COMMUNITY DEVELOPMENT DEPARTMENT  
80 Columbia Avenue ♦ Marysville, WA 98270  
(360) 363-8100 ♦ (360) 651-5099 FAX

Re: Marysville Corporate Center – *Technical Review 1*  
PA 22004

RE: Marysville Corporate Center, File# PA22-004  
Binding Site Plan  
15908 47<sup>th</sup> Ave., Multiple Parcels

Know what's below.
 Call before you dig.

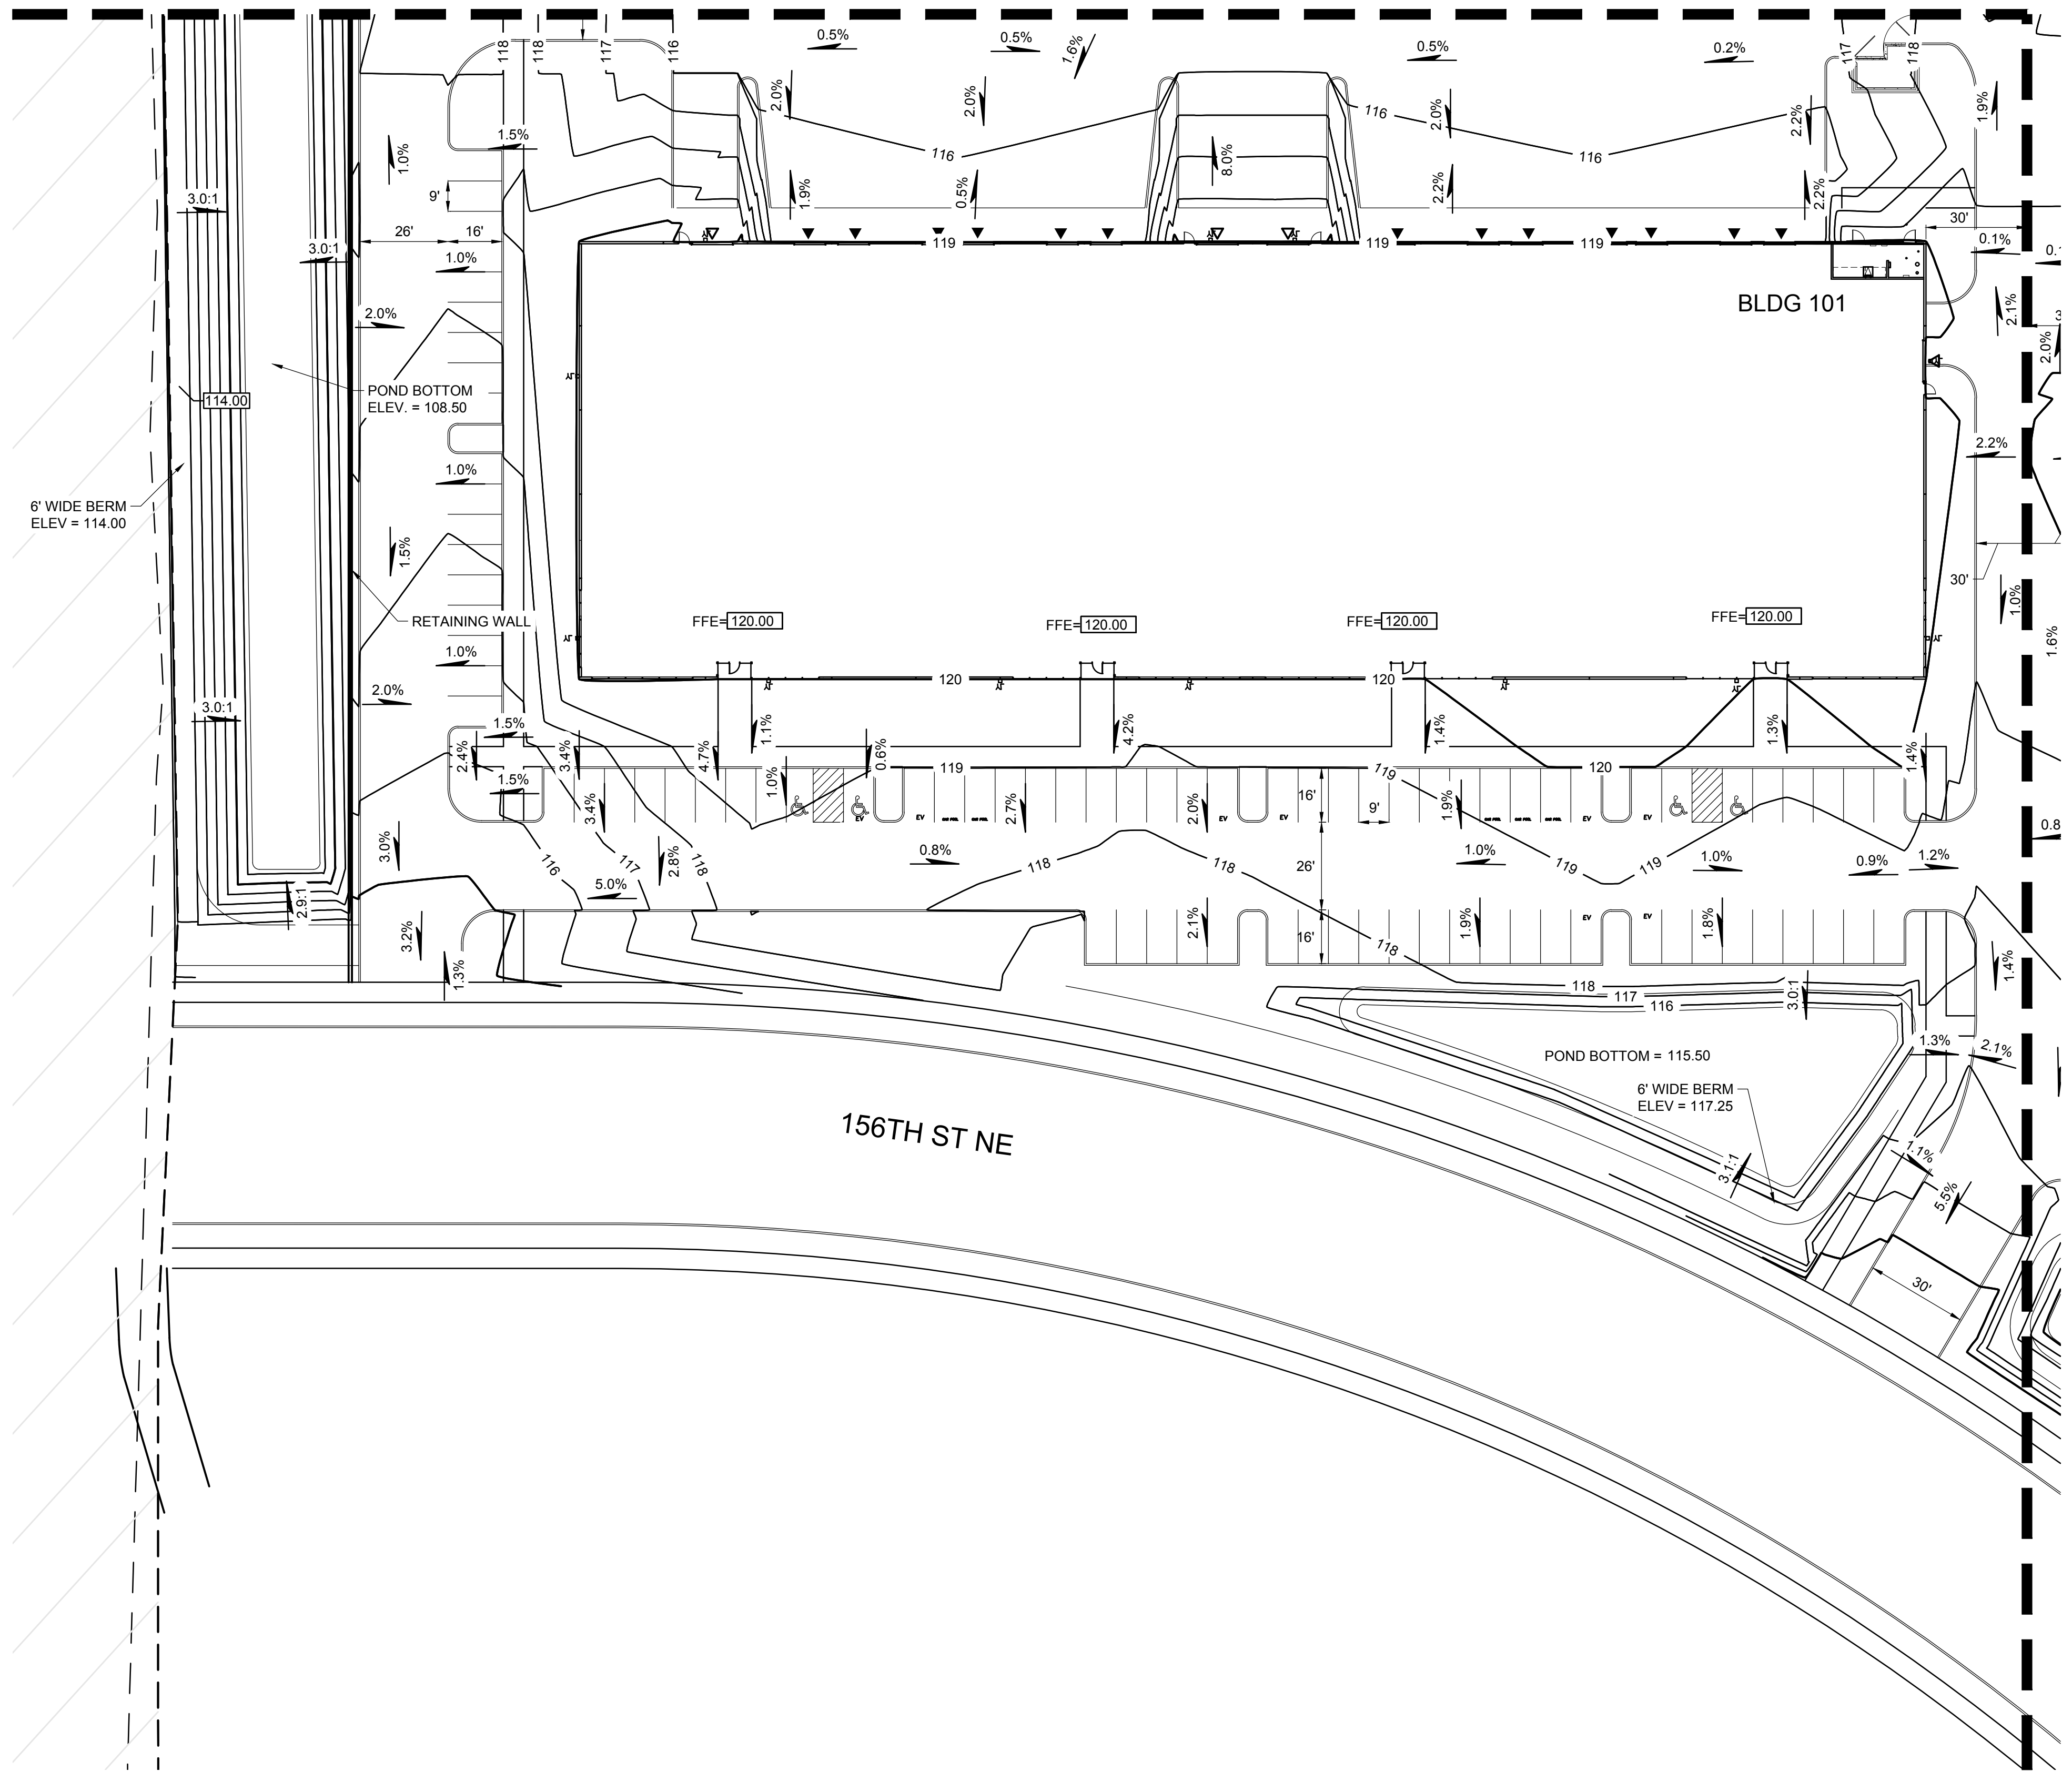
7. Survey control datum NAVD-88 and NAD-83 are required to be used. Civil construction plans will not be accepted in any other datum.
8. The onsite grading and placement of any retaining walls must be compliant with section 22D.050.030 of the MMC.

UTILITY PLAN - NW

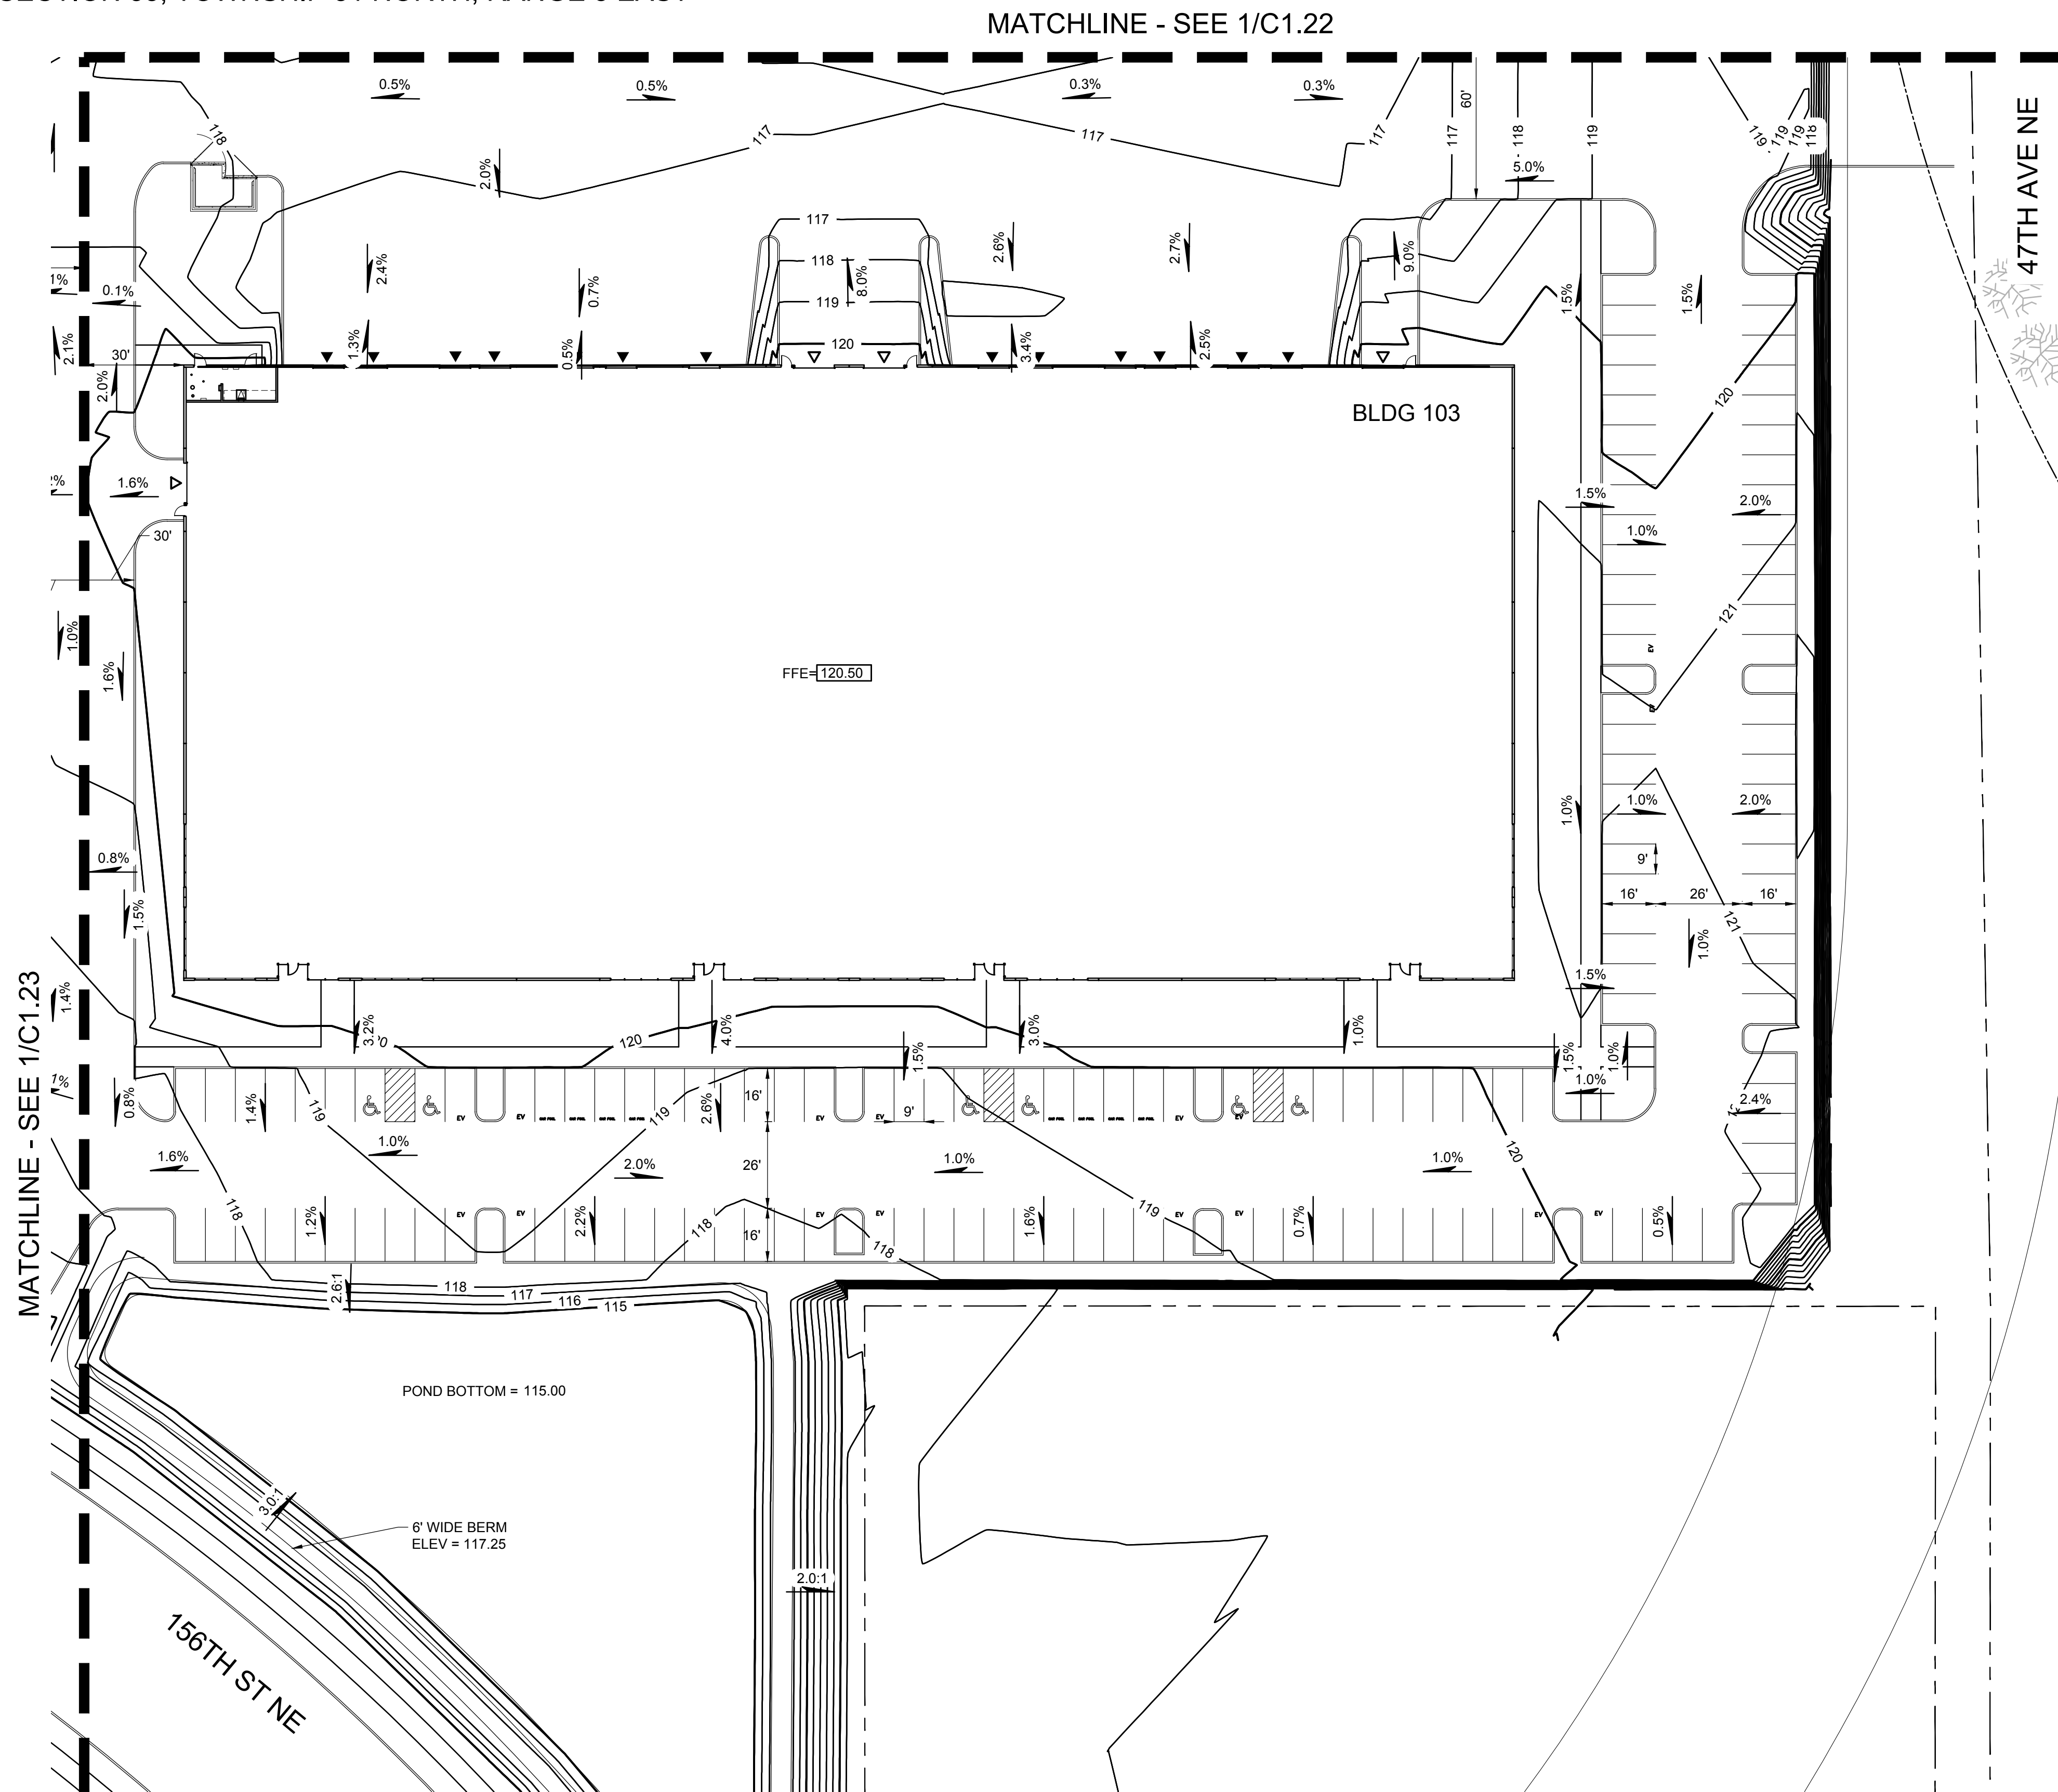
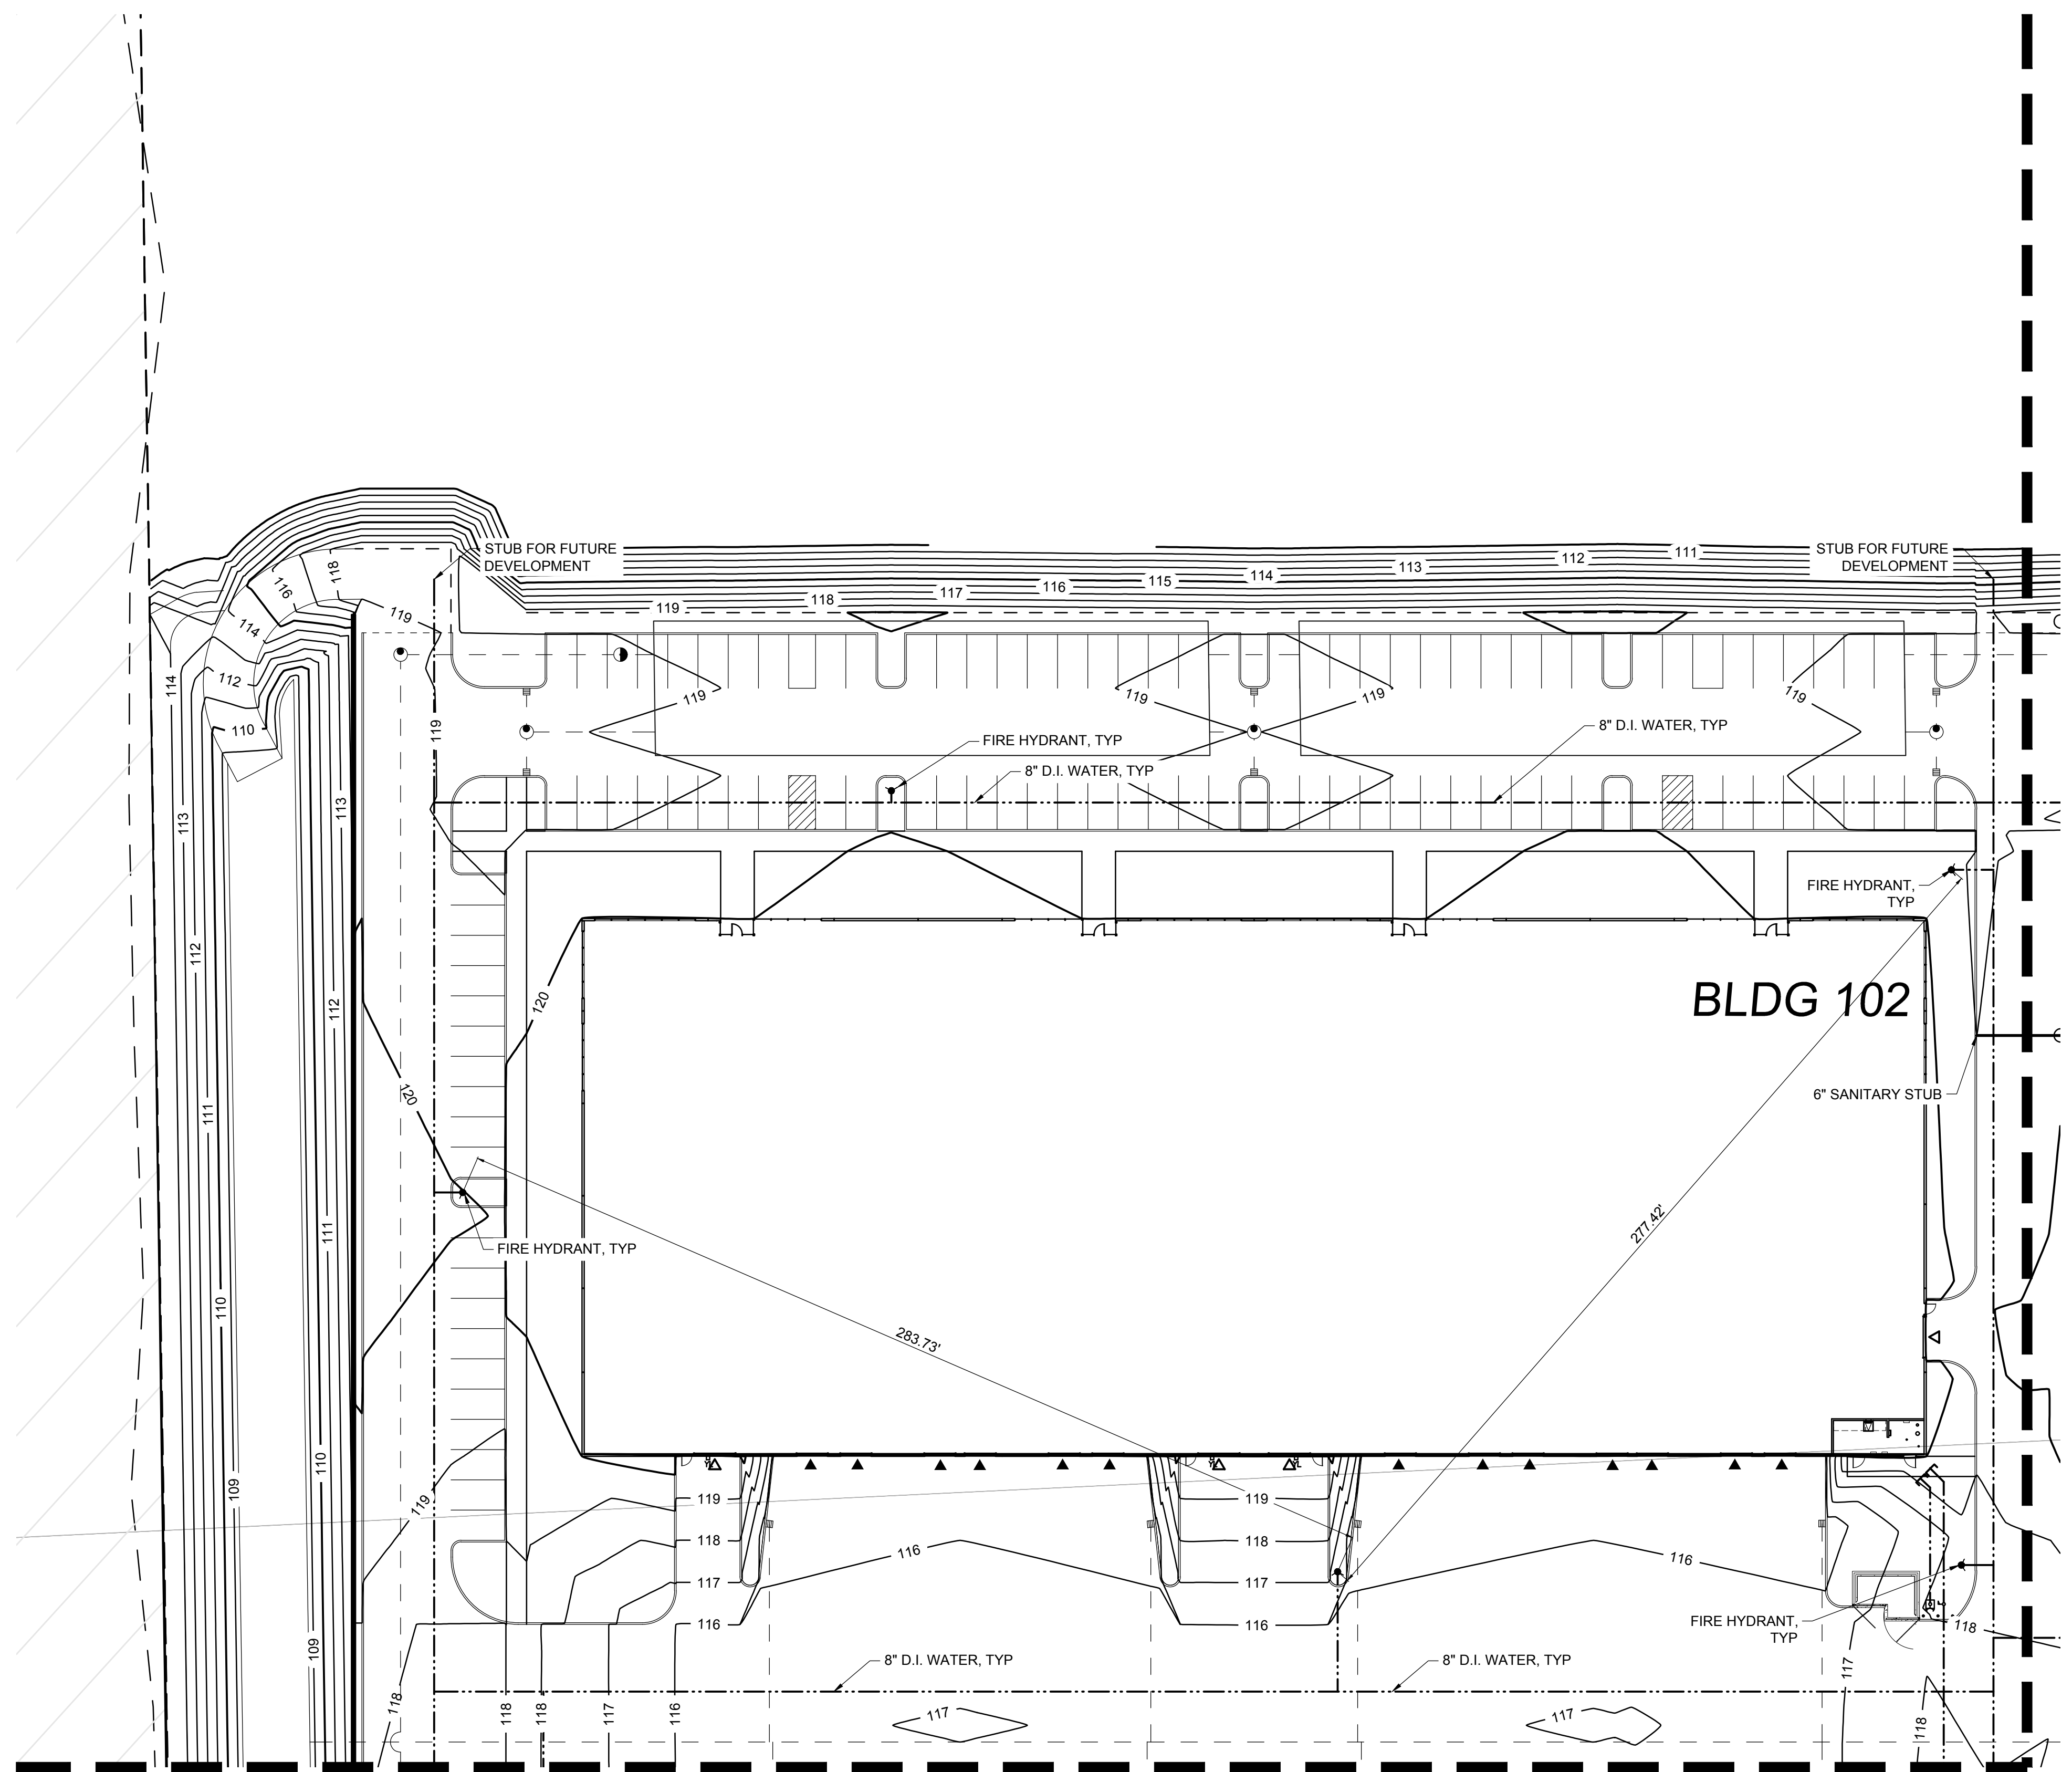
1. **Existing utilities:**
  - a. Sanitary sewer: The sewer manhole in 156th Street NE adjacent to the project is shown on RD325. The 18 inch trunk line, west of the project is shown on record drawing S619.

- b. Water: The waterline within 156th Street NE is available on RD325.
  - c. Storm: The storm drainage in 156th Street NE is also on RD325.
2. Per MMC 14.03.250, utilities are to be extended along the street frontages of the proposed project. Sanitary sewer and water mains shall be installed within the new City roads. Storm drainage facilities shall also be supplied for the new City roadways that are to be constructed.
